## COMMENT RESPONSE NARRATIVE

DATE: June 20, 2023  
PROJECT ARCHITECT: ELEVEN18 ARCHITECTURE, PL  
CONTACT NAME AND NUMBER: Matt Conte, AIA LEED AP | 407-745-5300

PROJECT NAME: **The Springs of Ballentine**  
PERMIT NUMBER:

PLEASE NOTE THE FOLLOWING REVISIONS TO THE PROPOSED SET OF DRAWINGS HAVE BEEN COMPLETED IN RESPONSE TO THE NORTH CAROLINA DEPARTMENT OF HEALTH AND HUMAN SERVICES FOR THE ARCHITECTURAL REVIEW DATED 4/12/2023 AND MEP REVIEW DATED 6/7/2023 AS WELL AS CITY COMMENTS DATE 6/13/2023.

**1 BUILDING SECTION**  
 1/2" = 1'-0"

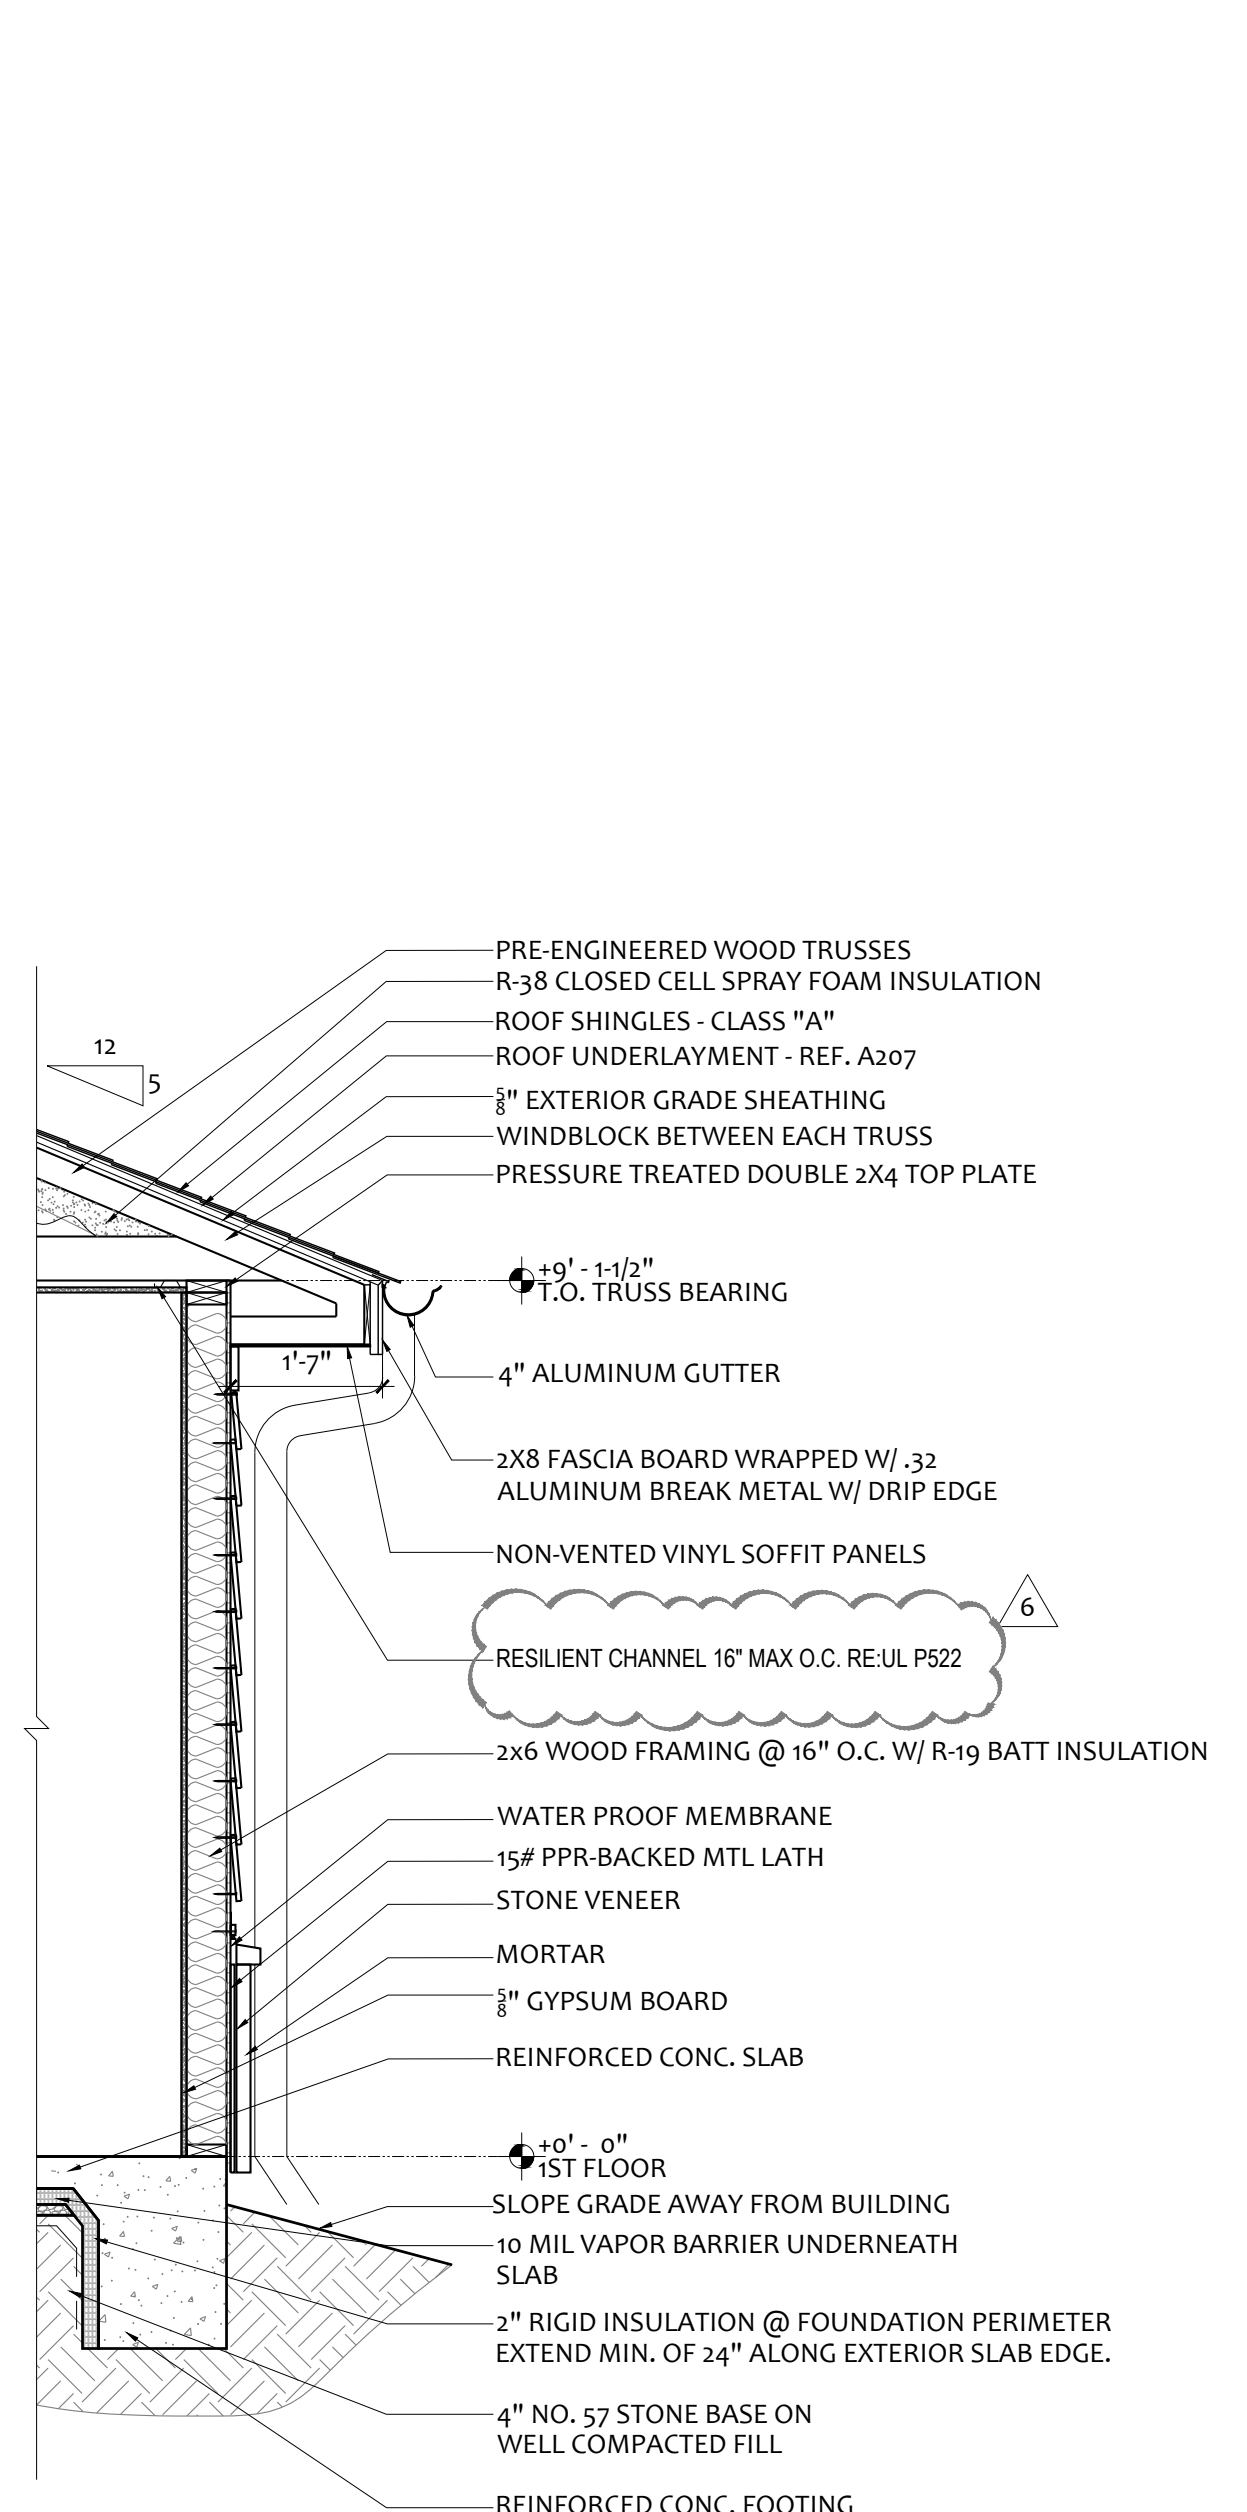
**3. The 1-hour roof ceiling assembly P522 on Sheet A006 was tested with specific products. Please submit confirmation that that specific product was used if this assembly is used with the 16" on center resilient channels.**

**RESPONSE:** P522 on sheet A006 has been moved to sheet A013 per revision 4. All sections and details have been updated from "hat track" to "resilient channel." Refer to revised sheets A302 – A305 and A401-A405. If another alternate product is used as part of P522 the contractor/architect will submit that information to the AHJ.
